**WELWYN HATFIELD BOROUGH COUNCIL
EXECUTIVE DIRECTOR - PLANNING, PUBLIC PROTECTION AND GOVERNANCE**

DELEGATED APPLICATION

Application No: 6/2016/2251/MAJ
Location: Beales Hotel Comet Way Hatfield AL10 9NG
Proposal: Erection of second floor extension to existing hotel, including a further 19 bedrooms and gymnasium (renewal of S6/2013/2174/MA)
Officer: Mrs J Pagdin

Recommendation: Granted

Beales Hotels
 Extension of Beales Hotel, Hatfield
 Proposed Elevations C and D

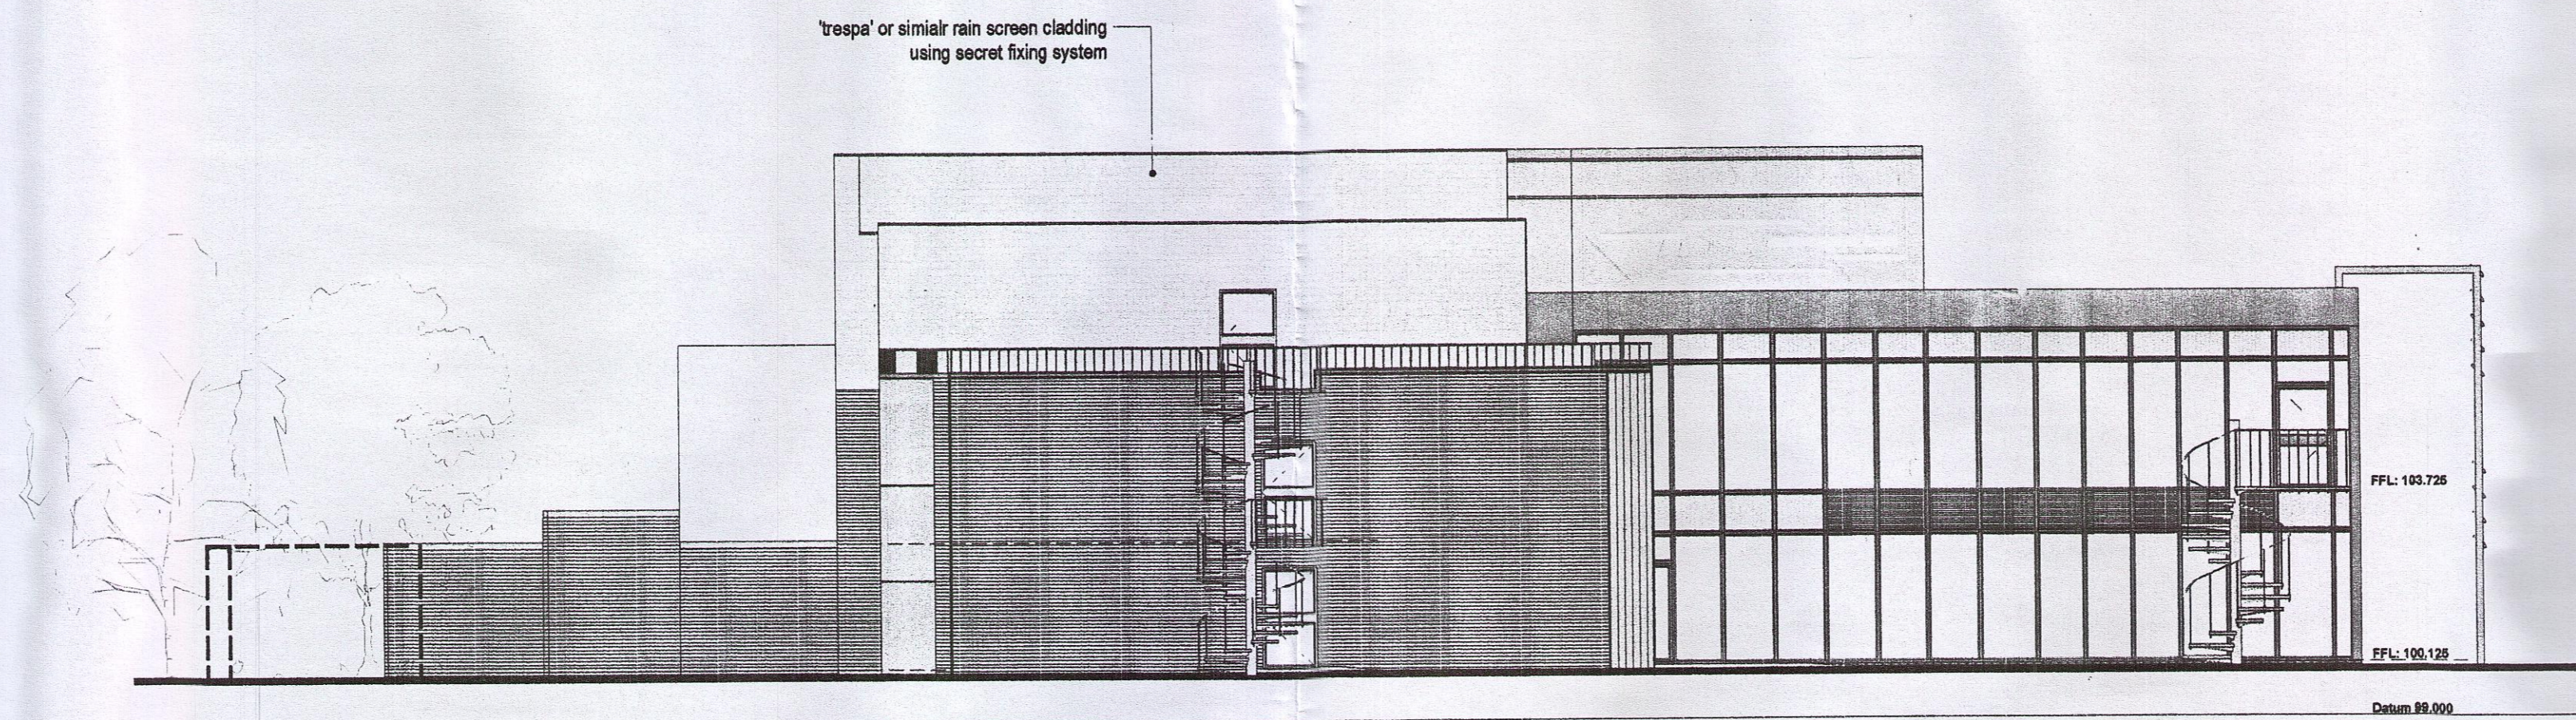
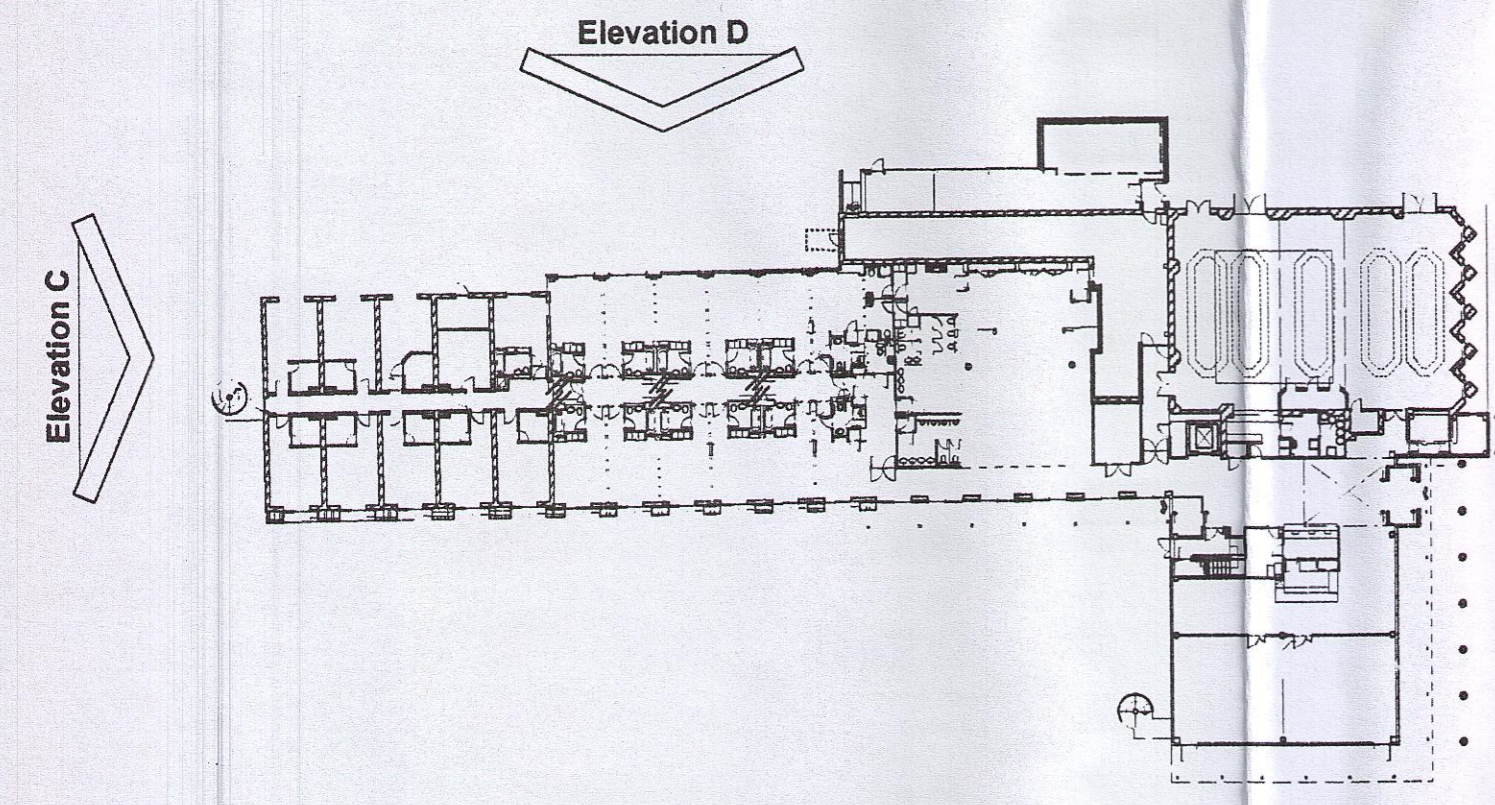
Impact on neighbours	Policies D1 and the Supplementary Design Guidance require the amenities and living conditions of neighbouring occupiers to be maintained and respected by new developments. <p>The neighbouring properties most likely to be affected are to the north of the application site in the residential flats above the shops in Parkhouse Court. The previous considerations of the likely impact on these flats found the proposal to be acceptable. The flats at Parkhouse Court were constructed while the previous applications at this site were extant. Issues of overbearing impact loss of light and overlooking were previously assessed and found to be</p>

<p>in accordance with Policy.</p> <p>The neighbour objection has raised the issue of overlooking between the second floor bedrooms and the flats in Parkhouse Court. Twelve bedrooms would have their windows facing north. The flats in Parkhouse Court have balconies and habitable rooms facing south. However, the distance between them is 18m, which was previously (S6/2013/2174/MA) considered to be a sufficient distance to prevent significant loss of privacy. However, the proposed windows are picture style windows comprised of four clear panels and the presence of windows can create an impression or perception of overlooking, which has been recognised as material in determining planning decisions. The applicants were asked to consider frosted glazing in some of the panels but did not capitulate. However, a condition requiring full length blinds to be fitted to the windows (as are used in the existing windows on the floor below) is recommended in order to reduce the perception of overlooking.</p> <p>Subject to this condition the application is considered acceptable with regard to impact on neighbouring occupiers.</p>

1. No development shall take place until samples of the materials to be used in the construction of the external surfaces of the north elevation of the extension hereby granted have been submitted to and approved in writing by the Local Planning Authority. The development shall be implemented using the approved materials and subsequently, the approved materials shall not be changed.

2. The north facing second floor windows of the proposed extension shall be fitted with full-length blinds up to a height of 1.8 metres above floor level, and shall be retained in that form thereafter.
